The Sizewell C Project

5.6Ad Sizewell Link Road Flood Risk Assessment Addendum - Appendices B-D Part 1

Sizewell C Sizewell Link Road Flood Risk Assessment Addendum – Appendix B: Collated Comments from the Environment Agency received on 5th February 2020 and 4th August 2020

Plate 2.5. Proposed cross-section of the diverted channel at crossing SW1.

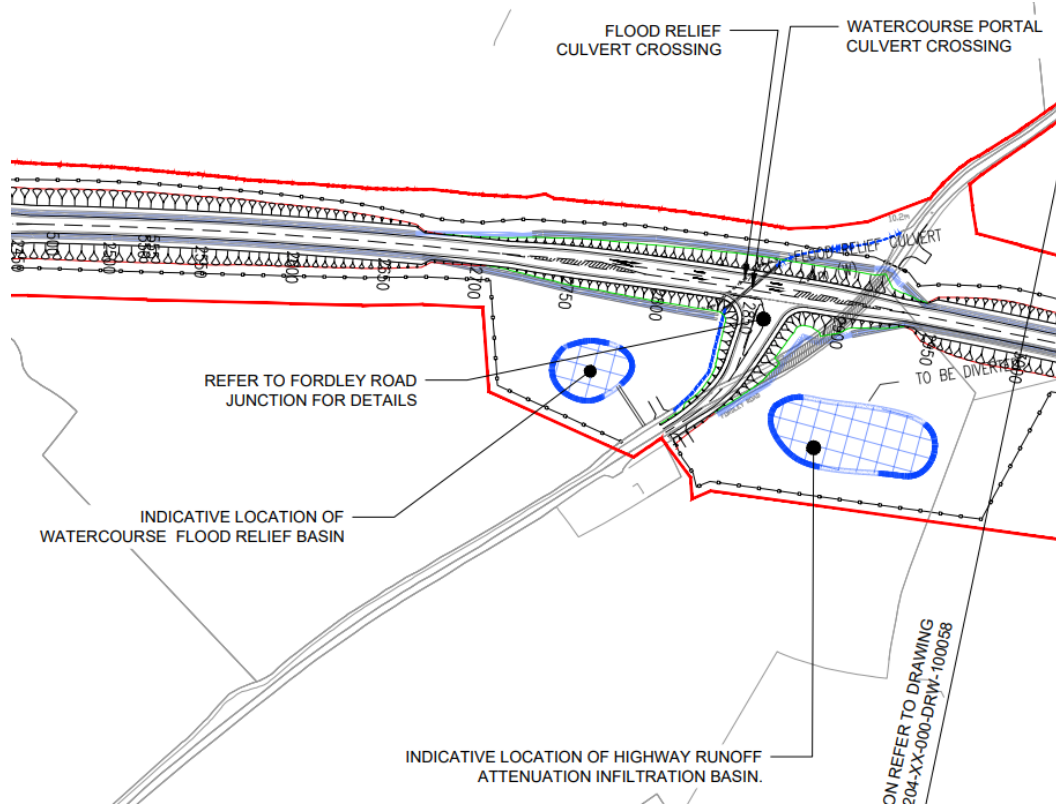
No.	Document Title	Paragraph number	Issue	Comment	Suggested solution	Priority	Date Raised	SZC Co.'s Response
6.1	Sizewell Link Road Fluvial Modelling Report	Plate 2.5	The proposed cross section of the new diversion channel at SW1 is substantially larger than the current watercourse.	The cross section of the existing watercourse is understood to be approximately 1.5m2 this drawing shows the top of the channel to be 9.4m wide which is much larger. The FRA also does not explain how the channel will be constructed. The new channel should be as natural as possible.	Please explain why the cross section shown has been chosen and why it does not replicate the existing channel. Provide cross sectional survey obtained to show existing channel dimensions to provide a comparison to the proposed design.	1	05/02/2020	Further details of the design of the re-aligned channel have been provided in the Modelling Report Addendum and the FRA Addendum.

Plate 2.6. Proposed cross-section through the portal culvert at crossing SW1.

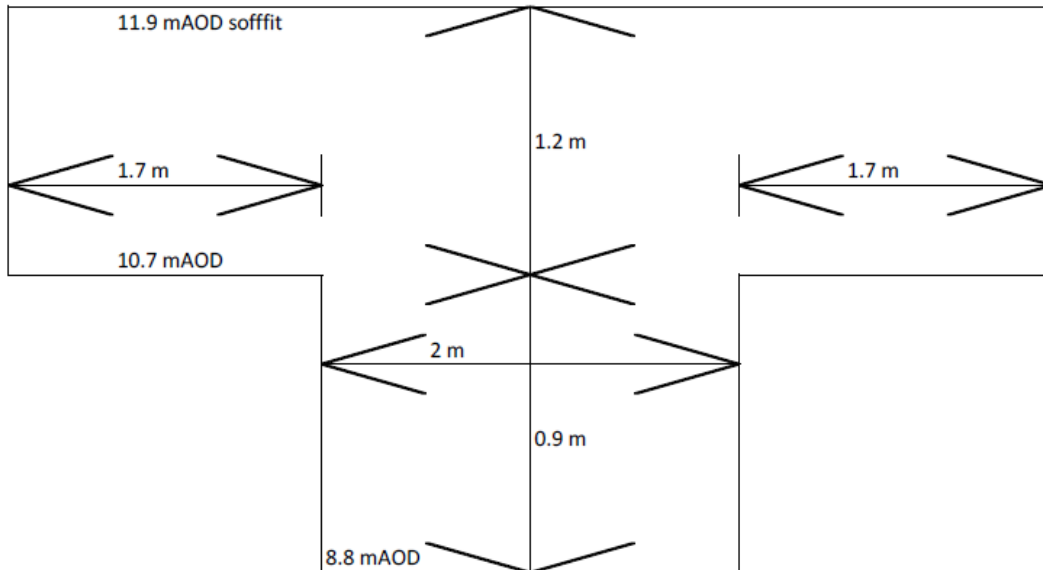
6.2	Sizewell Link Road Fluvial Modelling Report	Plate 2.6	SW1 crossing is now a T shaped concrete culvert. Material will be added to the bed and banks to naturalise the channel.	It is assumed that the cross sectional area shown in plate 2.6 and the model includes any material required to naturalise the culvert. This material could reduce capacity and impact on model results so must be included. It is not explained how or what sort of material will be used to create a natural bed and banks.	Confirm material will not reduce the capacity of the culvert and if it will this must be reflected in the modelling. Provide details on the material to be used to naturalise the bed and banks so we can determine it is suitable.	1	05/02/2020	Further details and clarification on the design and capacity of the culvert have been included in the Modelling Report Addendum.

Plate 2.7. Extract from EDF Energy link road drawing: SZC-SZ0204-XX-000-DRW-100140 P05 SLR Hawthorn Road Highway Junction Layout and Profile.

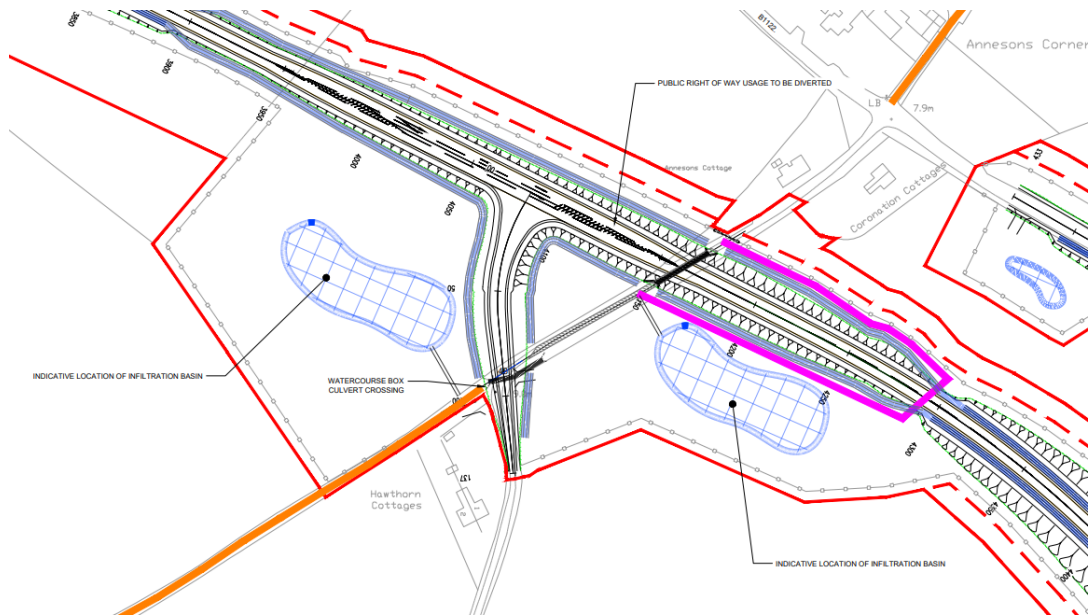
4.5	Sizewell Link Road Flood Risk Assessment	Plate 2.7	The proposed layout at SW3 is provided in plate 2.7, although this is not clear and appears unfinished.	It is not clear from the FRA or model report what the final design for the SW3 crossings are. It is understood an existing culvert will be extended with a portal culvert under Hawthorn Road and a flood relief culvert will also be installed. The description of the SW3 design in 2.2.21 does not appear to be consistent with the drawing in Plate 2.7	Provide clear plans and drawings for SW3 showing the existing and proposed arrangement. The information provided so far is not clear. Update the text to provide clarity and justify the final design in consultation with Suffolk County Council as it is an ordinary watercourse.	2	05/02/2020	Further design details (where available) have been discussed in the FRA Addendum.

5.9	Sizewell Link Road Fluvial Modelling Report	Plates 2.4 and 2.7	Plate 2.7 does not show where the flood relief culverts for crossing SW3 will be located. It is not clear how the locations of the proposed flood relief culverts relate to the modelled floodplain/outlines.	Plate 2.4 shows SW1 box culvert runs adjacent to portal culvert. A box culvert is shown on Plate 2.7 for SW3, but this is not clear. There is no mention of a portal culvert. Is this plan incomplete?	Provide updated final design arrangement plans and cross sectional drawings for SW1 to SW7.	2	05/02/2020	Further design details (where available) have been discussed in the Modelling Report Addendum.
6	Sizewell Link Road Fluvial Modelling Report	Plate 2.4	The surface water infiltration basin to the east of Fordley Road at SW1 is located on higher ground. As the surface water drainage design is not available it is difficult to understand how the road will drain to the infiltration ponds.	The field to the east of Fordley road where the infiltration basin is located is higher ground. Surface water is known to run off and drain to the low point at Fordley Road. The FRA should consider how to improve this in the first instance and must not increase flood risk as a result of the development.	Provide information on surface water drainage to Suffolk County Council. Evidence that flood risk will not be increased and where possible it has been reduced overall in line with paragraph 5.7.3 of National Policy Statement EN1 and paragraph 160 of the National Planning Policy Framework.	2	05/02/2020	Further details on surface water drainage design (where available) and flood risk have been provided in the FRA Addendum.

Plate 2.10. Proposed revised layout at crossing SW3 (Hawthorn Road).

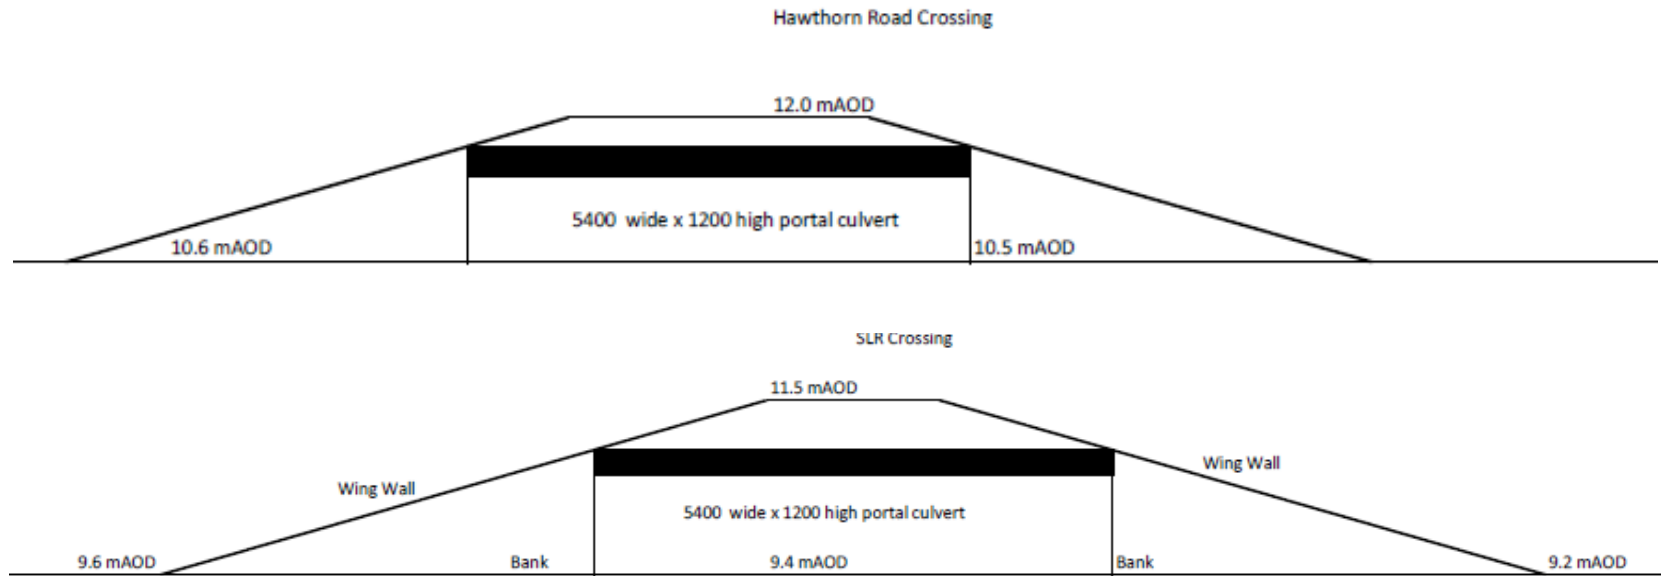
1.3	SZC_Bk5_5.6_AppxA_Sizewell_Link_Road_Modelling_Report.pdf	Plate 2.10/Hydraulic model	Discordance between what is shown in Plate 2.10 and what is represented in the hydraulic model at crossing SW3	Proposed revised layout at crossing SW3 long sections do not align with the dimensions shown in the model. Particularly the bank levels. For example Plate 2.1 suggests a bank level through the culvert of 9.4mAOD but inspection of section SW3_C2us reveals this (9.4m) looks more like portal culvert soffit level. Similarly for the Hawthorn Rd Crossing culvert the bank levels shown in Plate 2.10 don't seem to tie in with those shown in cross section SW3_C1us.	Correct the model or plate in the report depending on which is incorrect	1	14/09/2020	The model has been revised with additional survey data and the latest / improved (where required) design information. Updated results and further details on the modelling are provided in the Modelling Report Addendum.

Plate 2.11. Proposed layout at crossing SW5.

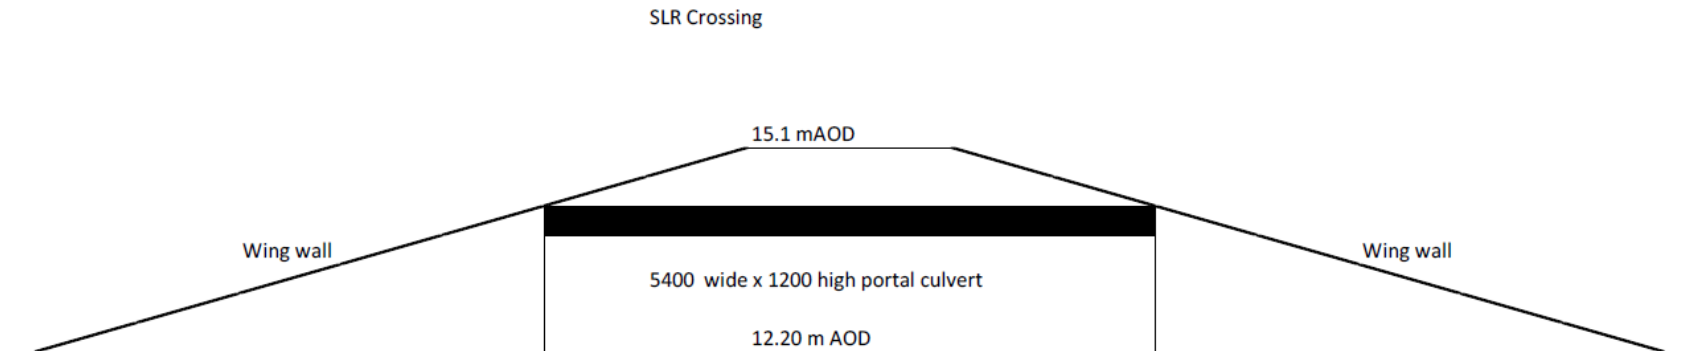
1.4	SZC_Bk5_5.6_AppxA_Sizewell_Link_Road_Modelling_Report.pdf	Plate 2.11/Hydraulic model	Discordance between what is shown in Plate 2.11 and what is represented in the hydraulic model at crossing SW5	The proposed layout for SW5 is at odds with what is represented in the model. Plate 2.11 shows a 5400mm wide 1200 high culvert yet cross section SW005B shows a width of 6.4 metres. In addition the bank heights do not align, Plate 2.11 shows 12.2mAOD but the model suggests bank levels are lower than that	Correct the model or plate in the report depending on which is incorrect	1	14/09/2020	The model has been revised with additional survey data and the latest / improved (where required) design information. Updated results and further details on the modelling are provided in the Modelling Report Addendum.

Plate 2.12. Proposed layout at crossing SW6.

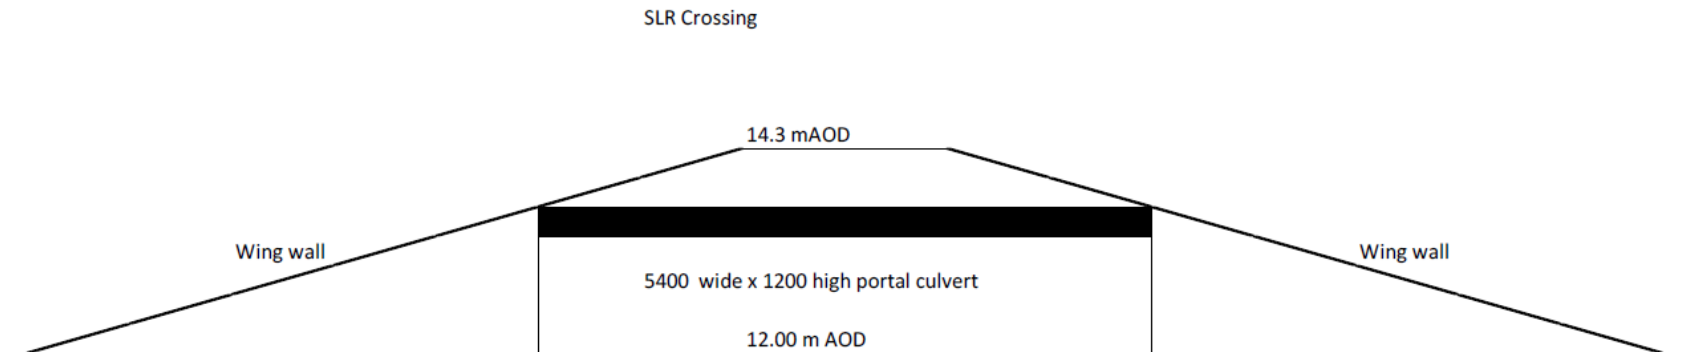
1.5	SZC_Bk5_5.6_AppxA_Sizewell_Link_Road_Modelling_Report.pdf	Plate 2.12/Hydraulic model	Width at SW6 seems to be larger than the 5400mm shown on Plate 2.12	The width in the model at SW6 is larger than 5400mm. Cross section SW006B shows a width of 5.7m	Correct the modelled width at SW6	1	14/09/2020	The model has been revised with additional survey data and the latest / improved (where required) design information. Updated results and further details on the modelling are provided in the Modelling Report Addendum.
